CITY OF ALBUQUERQUE

**Re: Anthea 4th and Granite, Conceptual Grading and Drainage Plan
Engineer's Stamp Date 6-17-14 (J14/D171)**

GRADING AND DRAINAGE PLAN

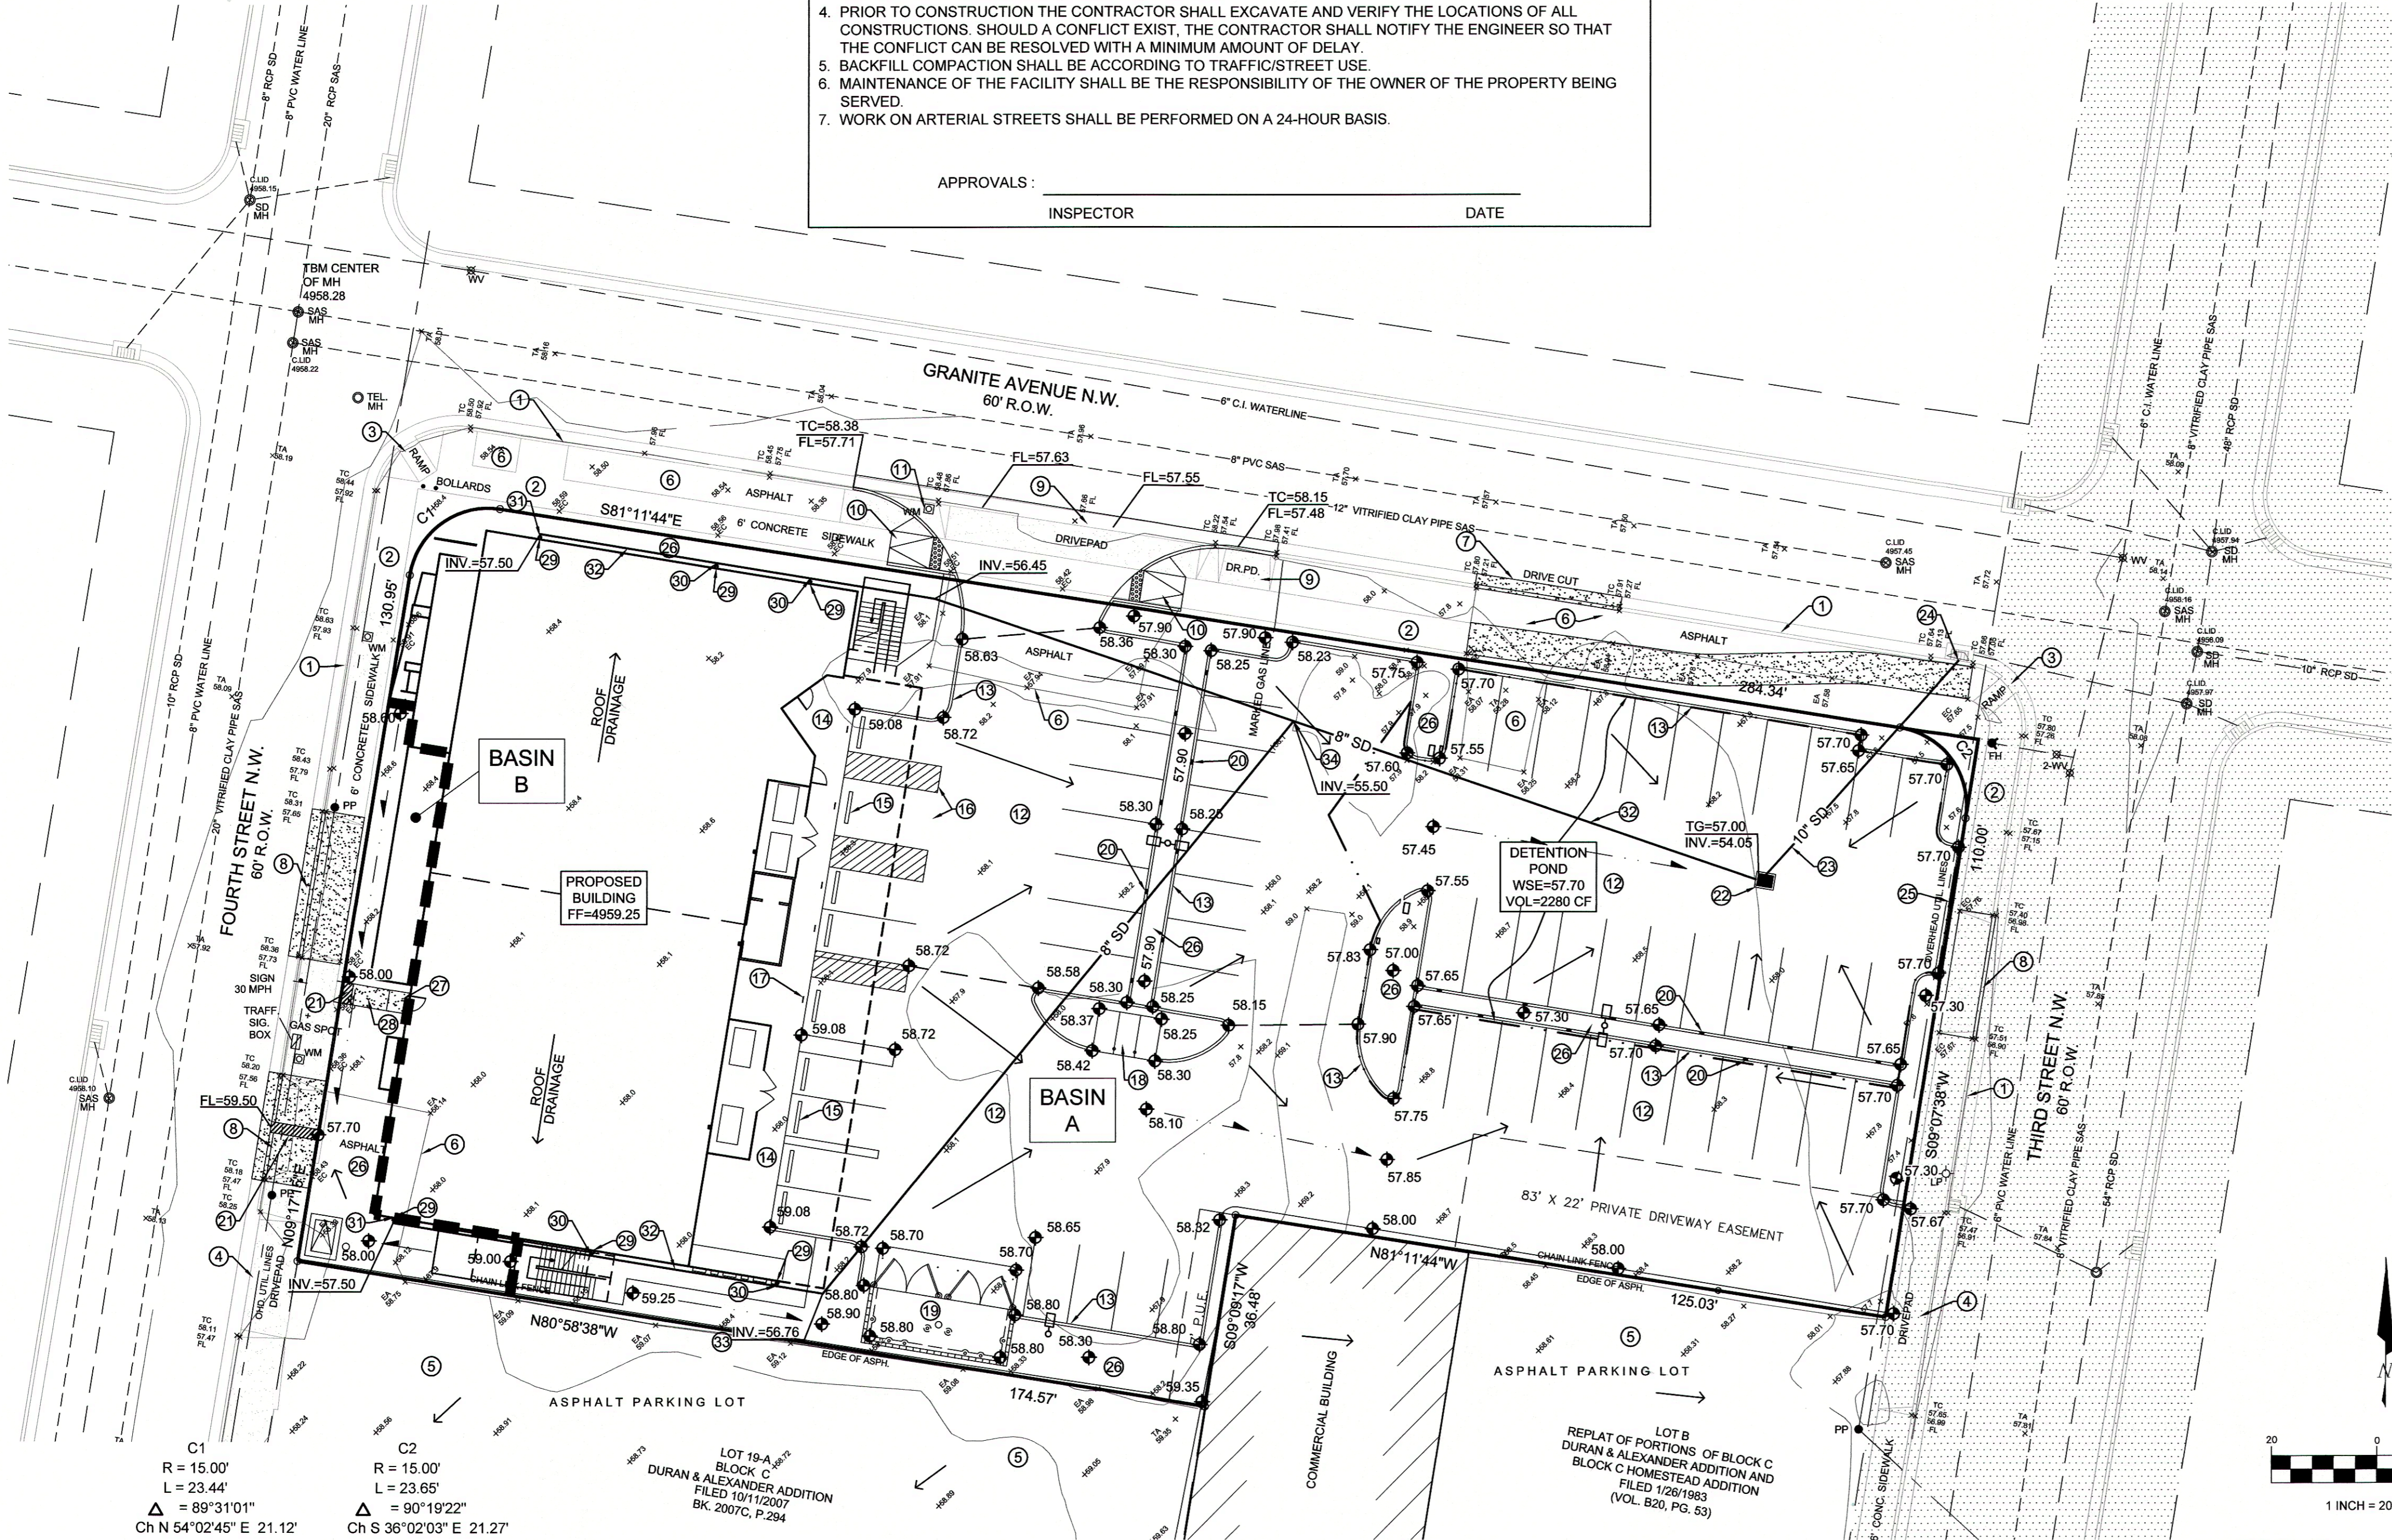
Based upon the information provided in your submittal received 6-17-14, the above referenced plan is approved for Site Plan for Building Permit action by the DRB, because the drainage plan is conceptually correct. The flow line elevations appear to be approximately 5 feet higher on this plan than on a different plan that listed a benchmark.
